RE: Prestons Industrial and Distribution Centre (SSD 7155)

Thank you for notifying Sydney Water of the development listed above. We have reviewed the application and provide the following comments for your consideration.

DRAWING TITLE
YARRUNGA STREET TYPICAL DETAILS
DRAWING No. **C08753-11-DA74**

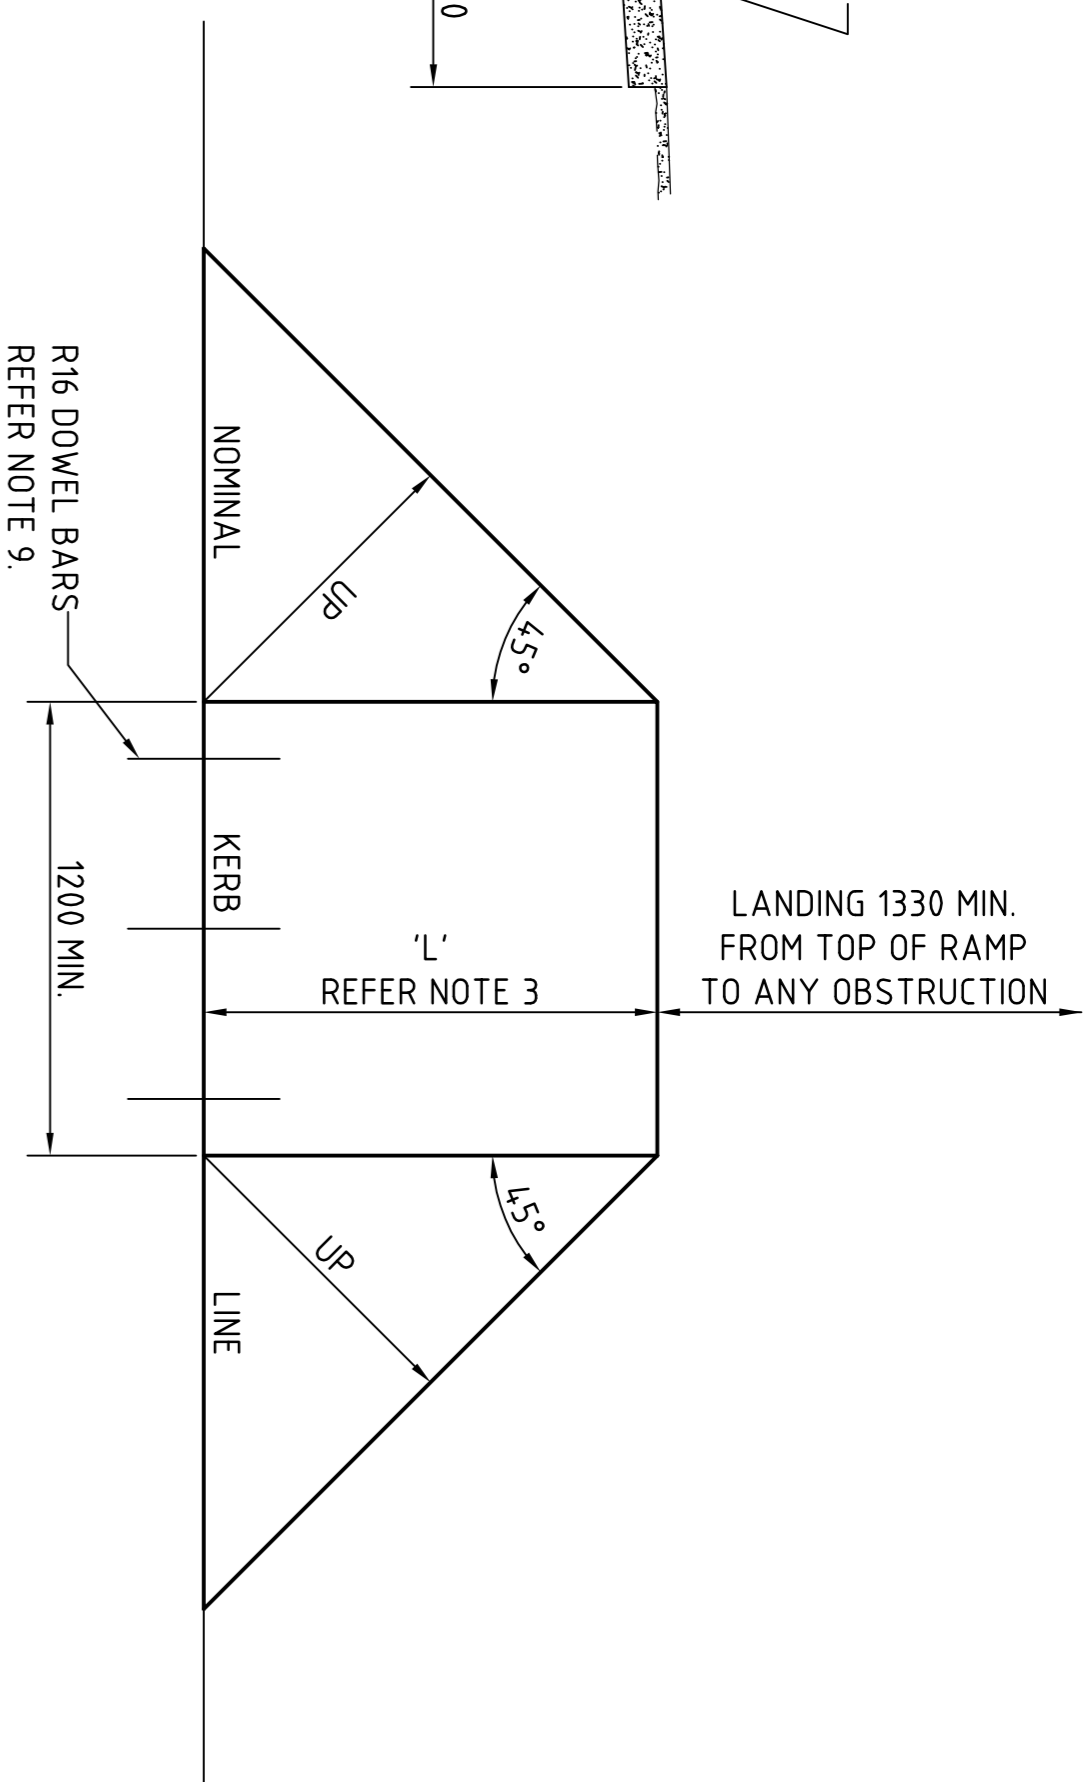
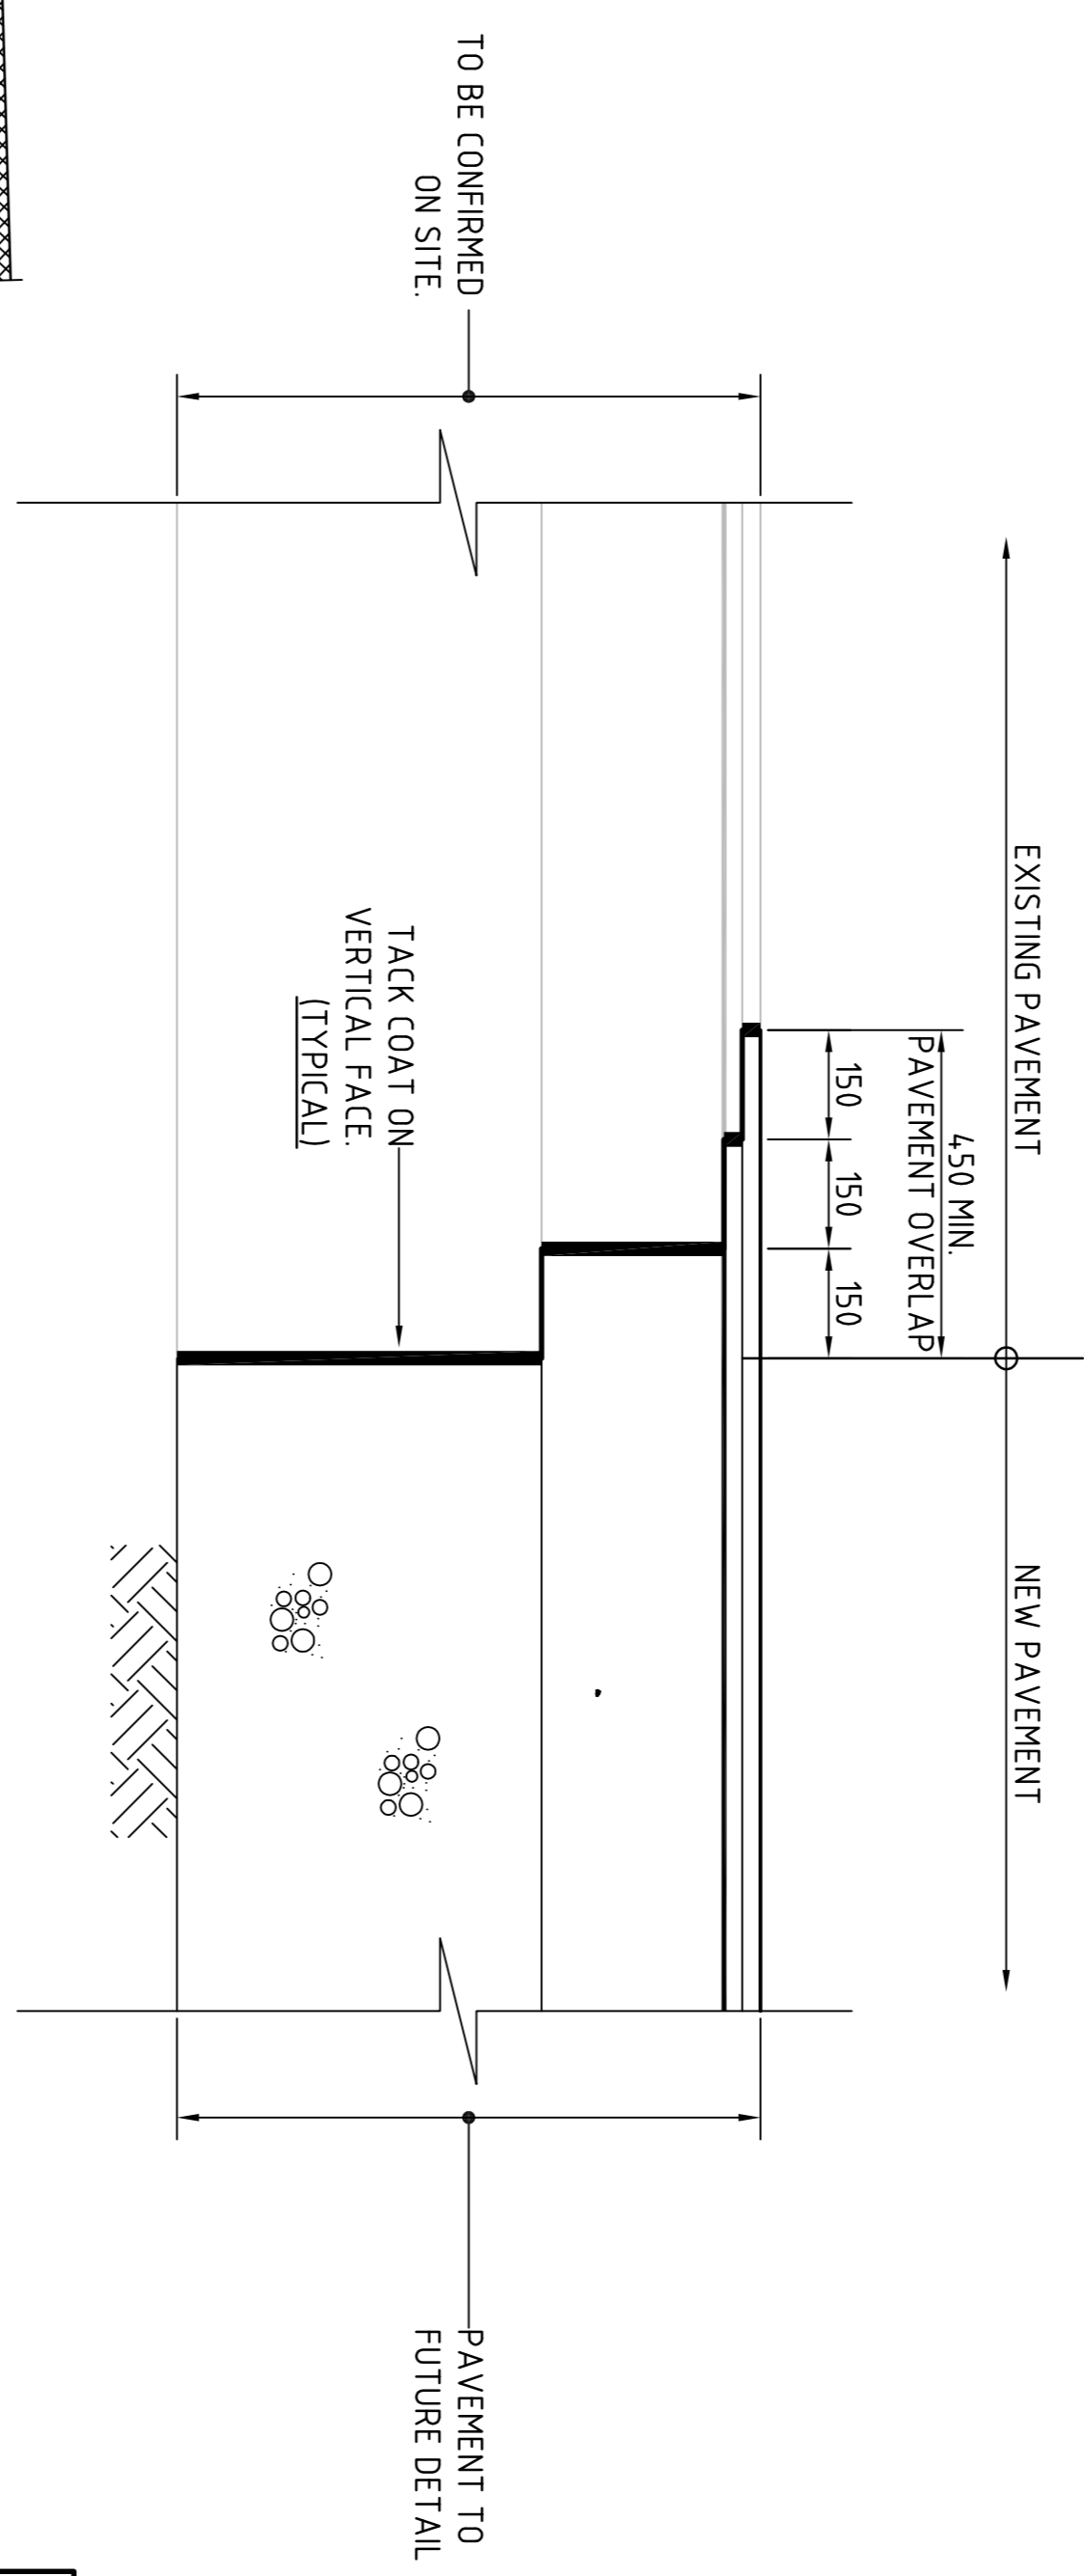
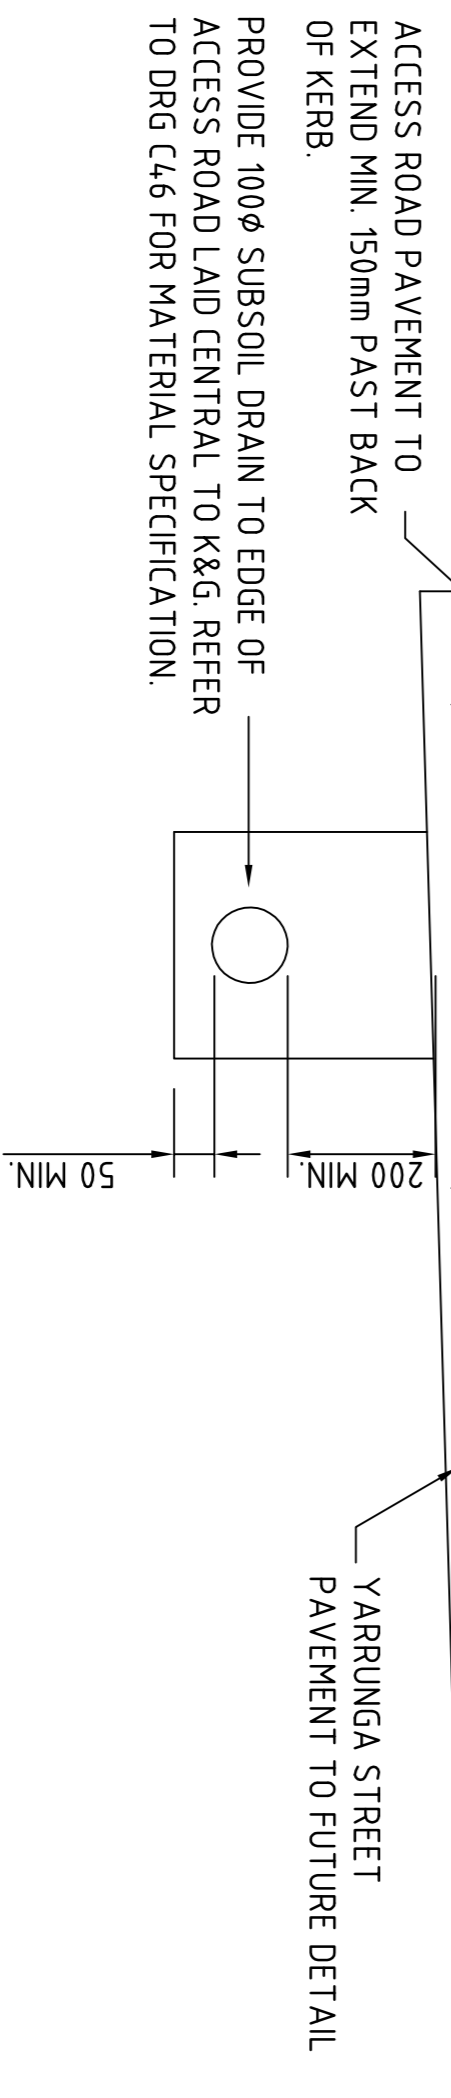
- The existing 100mm water main in Yarrunga Street will need to be amplified to a 150mm water main for the full frontage of the development.
- The new 150mm water main will be cross connected to the existing 250mm water main in Yarrunga Street. The proposed development will be served by this new 150mm main in Yarrunga Street.
- Detailed water requirements will be provided at the Section 73 application phase.

- A 150mm recycled water main extension will be required for the full frontage of the development from the existing 250mm recycled water main in Yarrunga Street.
- Detailed recycled water requirements will be provided at the Section 73 application phase.
